KITTITAS COUNTY COMMUNITY DEVELOPMENT SERVICES

RE: Riste Short Plat (SP-15-00007)

The Kittitas County Community Development Services Department has determined that the Riste Short Plat (SP-15-00007) is a complete application and hereby grants **preliminary approval**; final approval shall be subject to the following conditions:

# RISTE SHORT PLAT SP-15-00007

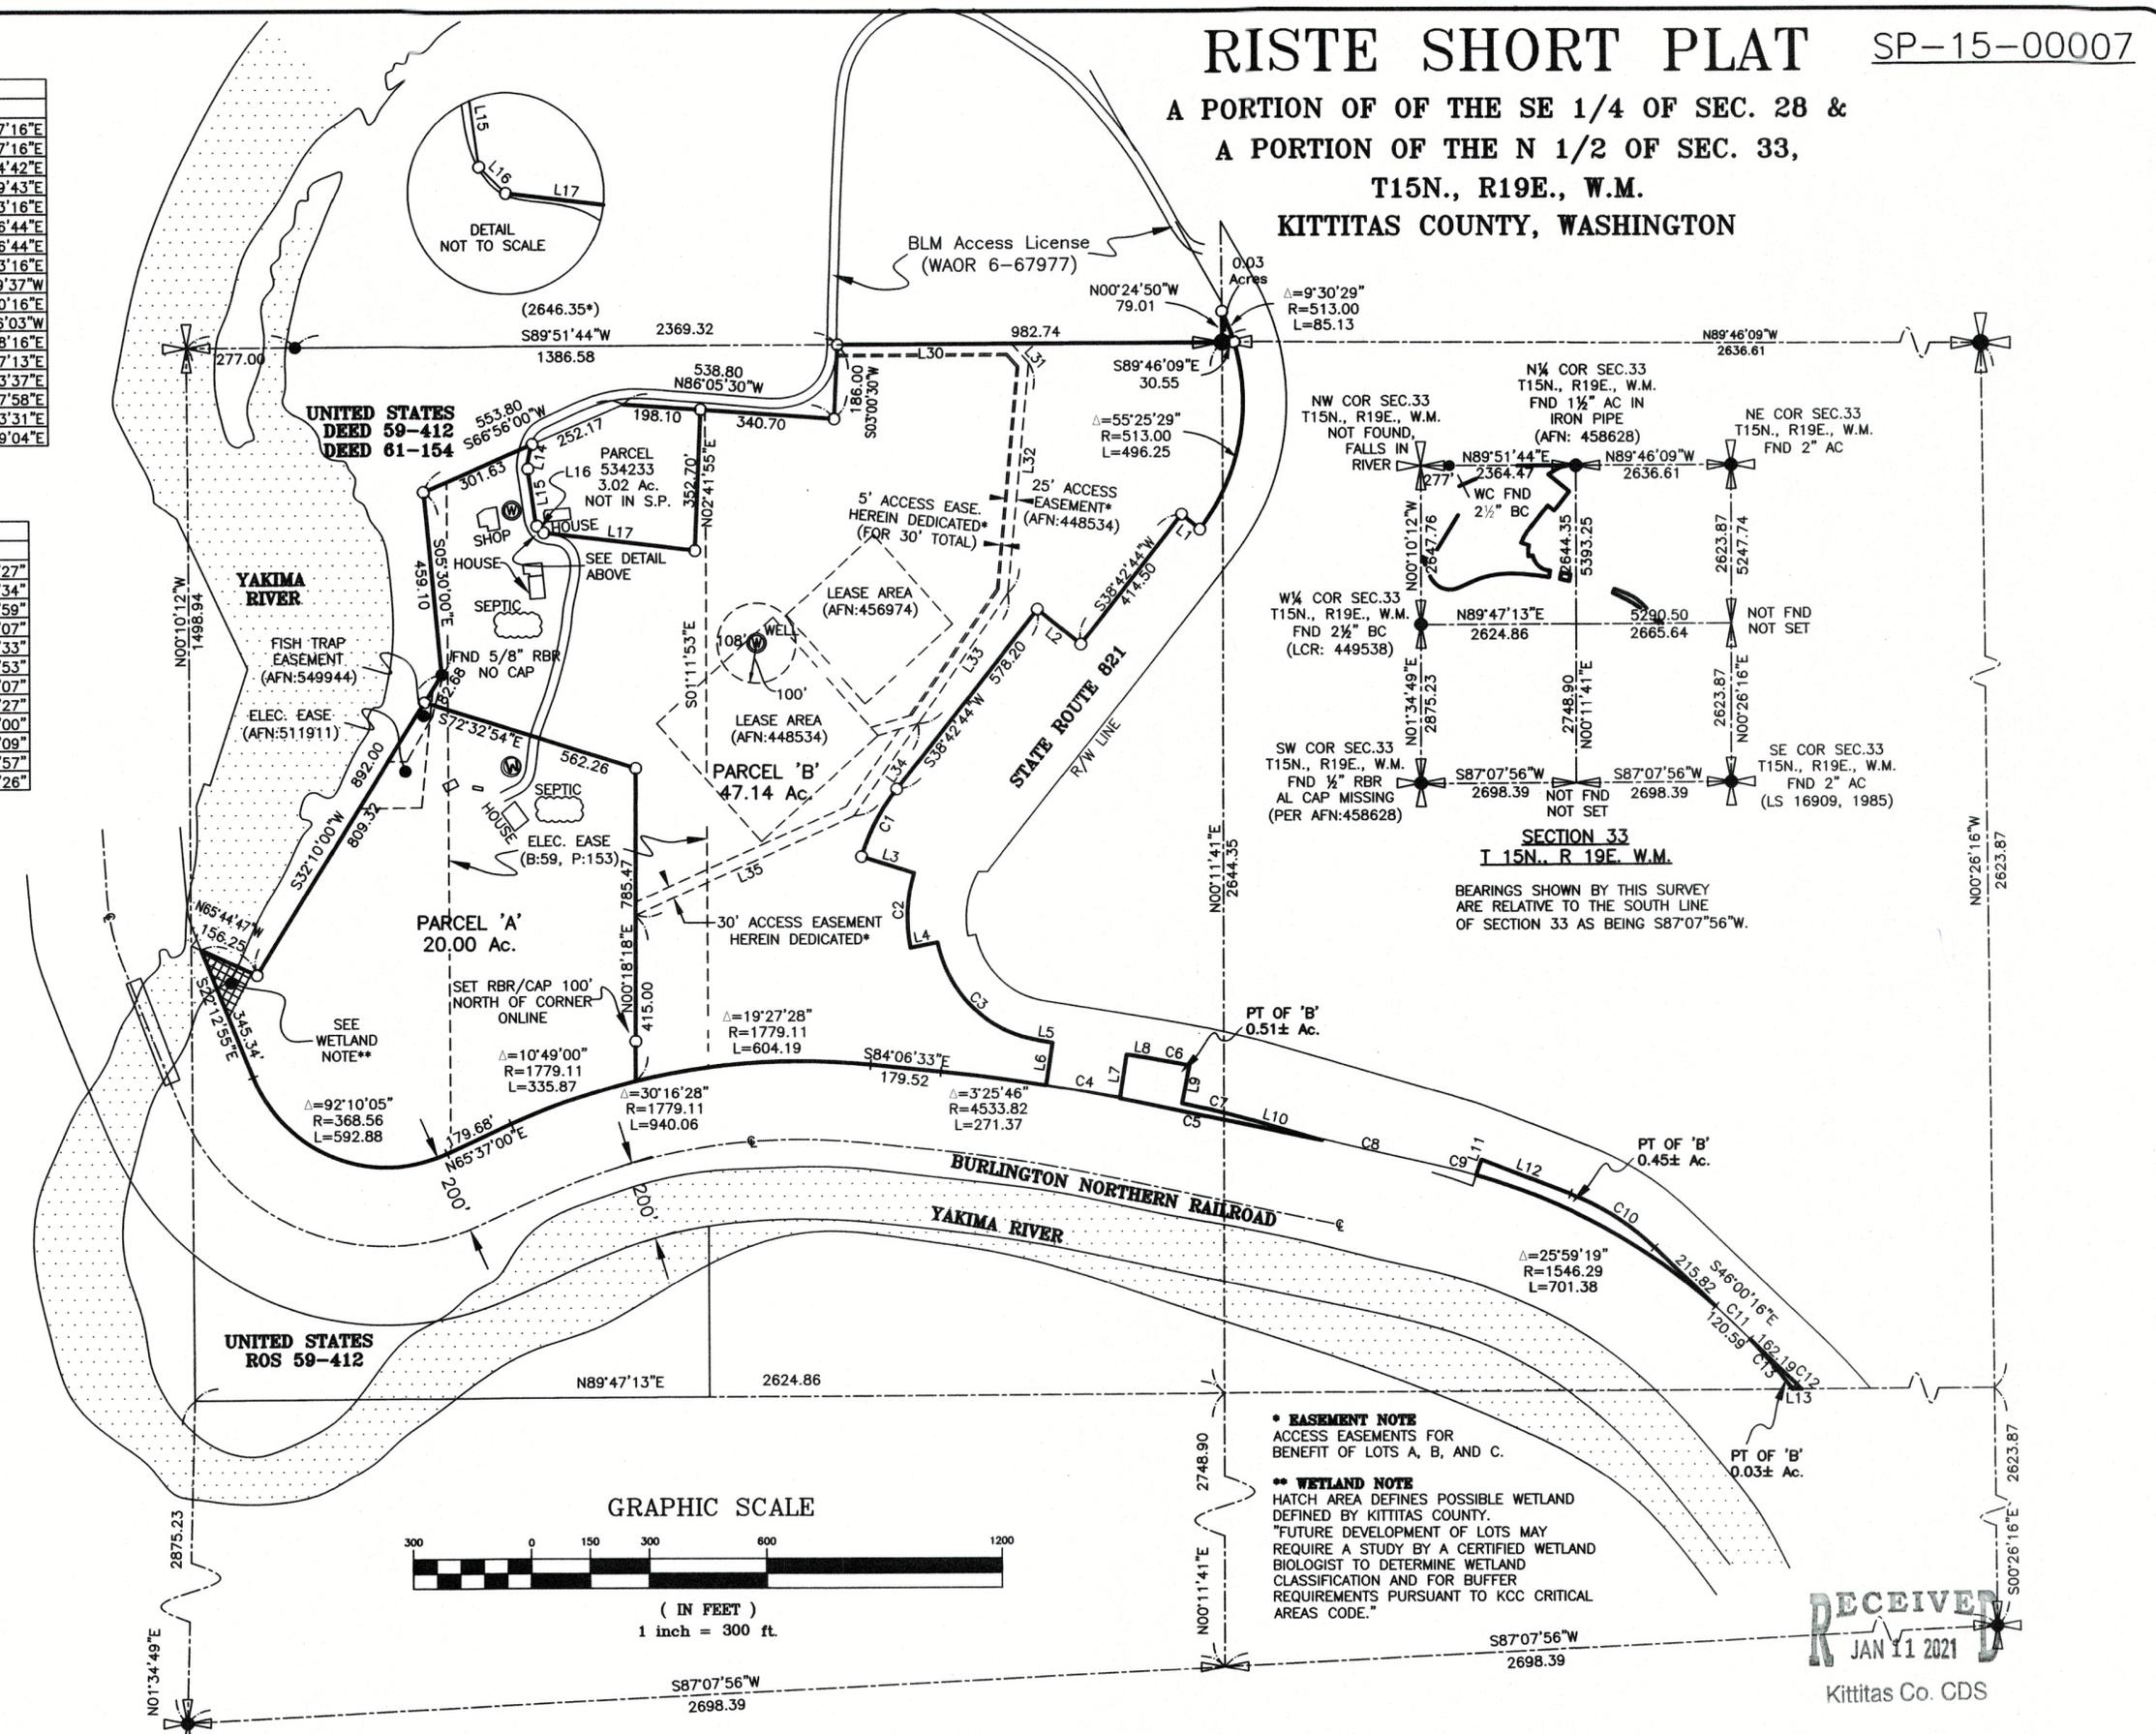
5. An access easement for Parcel "A" of the Riste Short Plat needs to be shown on the face of the short plat.
6. No driveway or road shall be constructed within five feet of the side yard boundary, unless the driveway or road is part of an easement shared with the neighboring property owner.

25. All future development must comply with International Fire Code (IFC) and appendices.
26. Parcel A and B of the Riste Short Plat may contain wetlands. The Final mylars shall reflect the location of these wetlands and a statement on the plat shall read as follows: "Future development of lots may require a study by a certified wetland biologist to determine wetland classification and for buffer requirements pursuant to KCC Critical Areas Code."

27. Parcel A and B of the Riste Short Plat may contain floodplain. The subject property contains areas designated on FEMA Flood Insurance Rate Map panel 5300950650B as having a 1 % or greater annual chance of flooding. Any development within these areas shall be subject to all applicable Federal, State, and County regulation. Kittitas County flood damage prevention code (KCC Chapter I 7 A.05; Ord. 93-18 by reference) requires any development within this area to obtain a permit. Flood insurance may be required for any structures on the subject properties.
